Application by Awel y Môr Offshore Wind Farm Limited for an Order Granting Development Consent for the Awel y Môr Offshore Wind Farm project

The Examining Authority's written questions and requests for information (ExQ1) Issued on 27 September 2022

Drawing file: EN010112 / EN010112-001327-6.22_D6_AyM_Statutory_Non_Statutory_Nature_Conservation_Sites_Plan_RevD.pdf

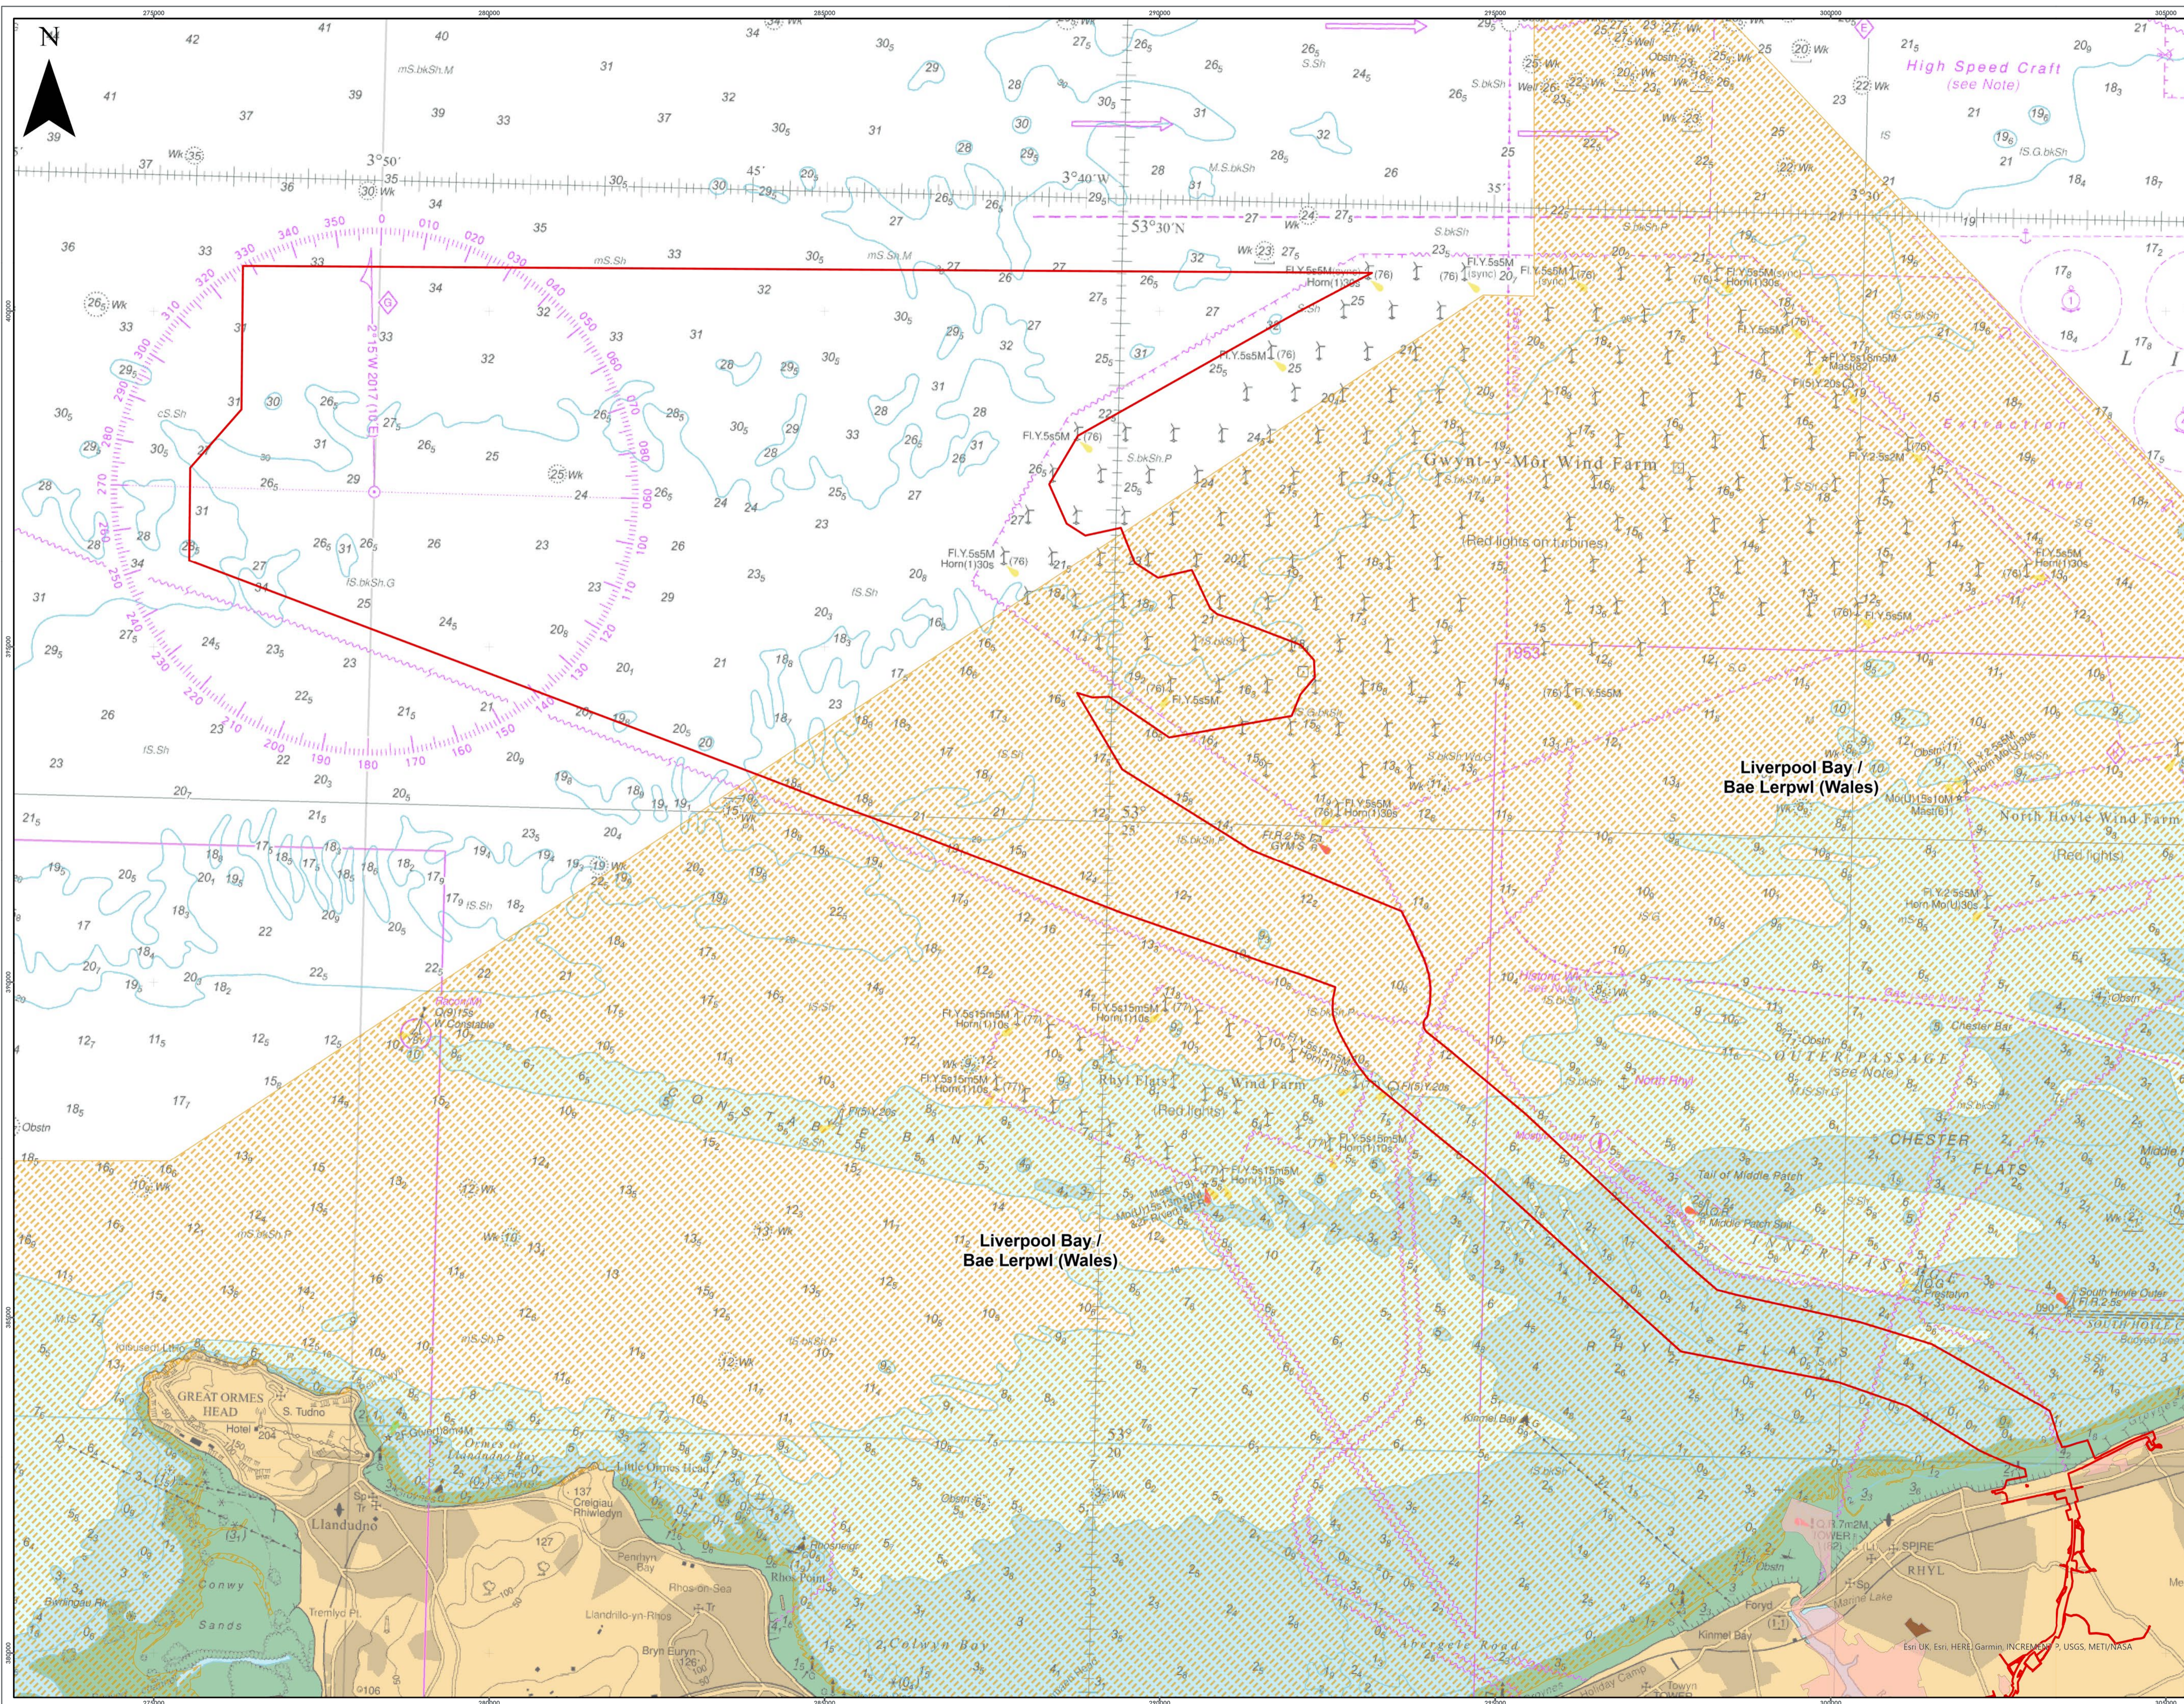
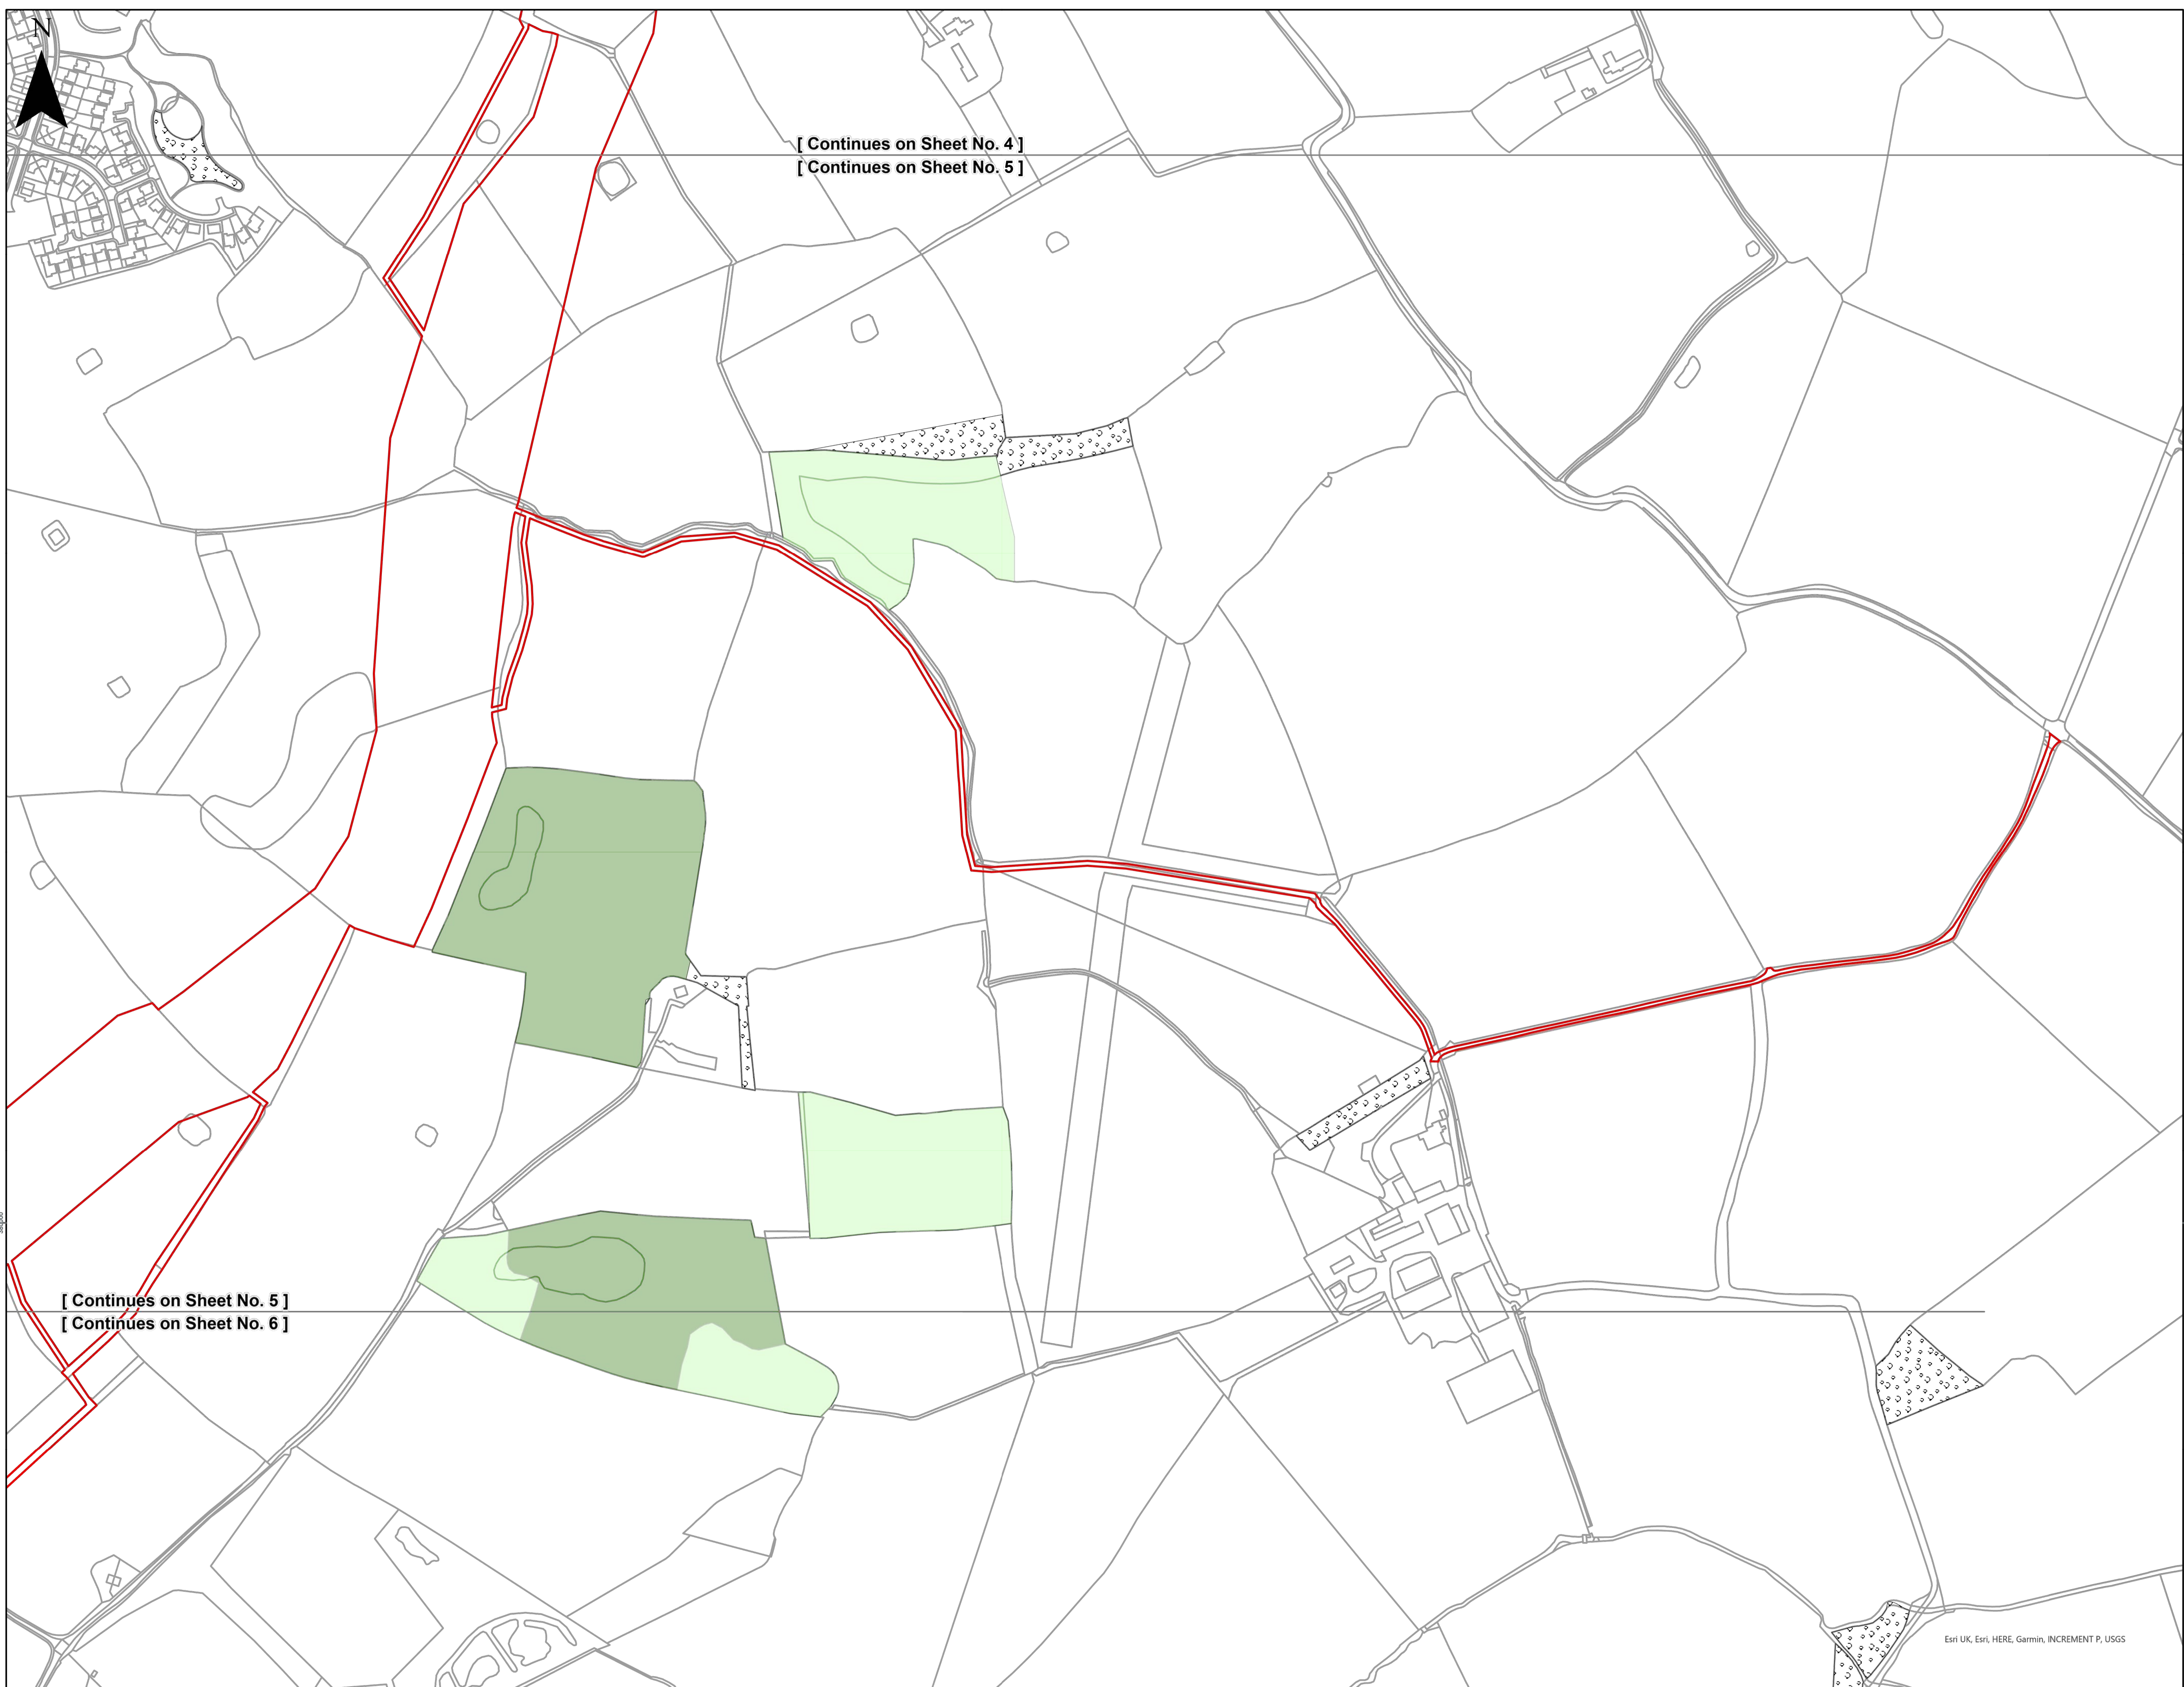
2.7	The Applicant	General Statutory / Non-statutory Nature Conservation Sites Plan [AS-010] Please can you address the following points: <ul style="list-style-type: none">a) Sheet 1 of 11 - The legend does not reflect all hatch colours shown and the extents of SPA hatch appears to be different on sheets 2 and 3;b) Sheet 2 of 11 –does the drawn shape and extent of Local Wildlife Sites at western edge reflects y Ffrith D011;c) differentiate the woodland area to help identify other ancient semi-natural woodland, plantation on ancient woodland site and local other woodland;d) label the name of the other nature reserves on the relevant sheet.
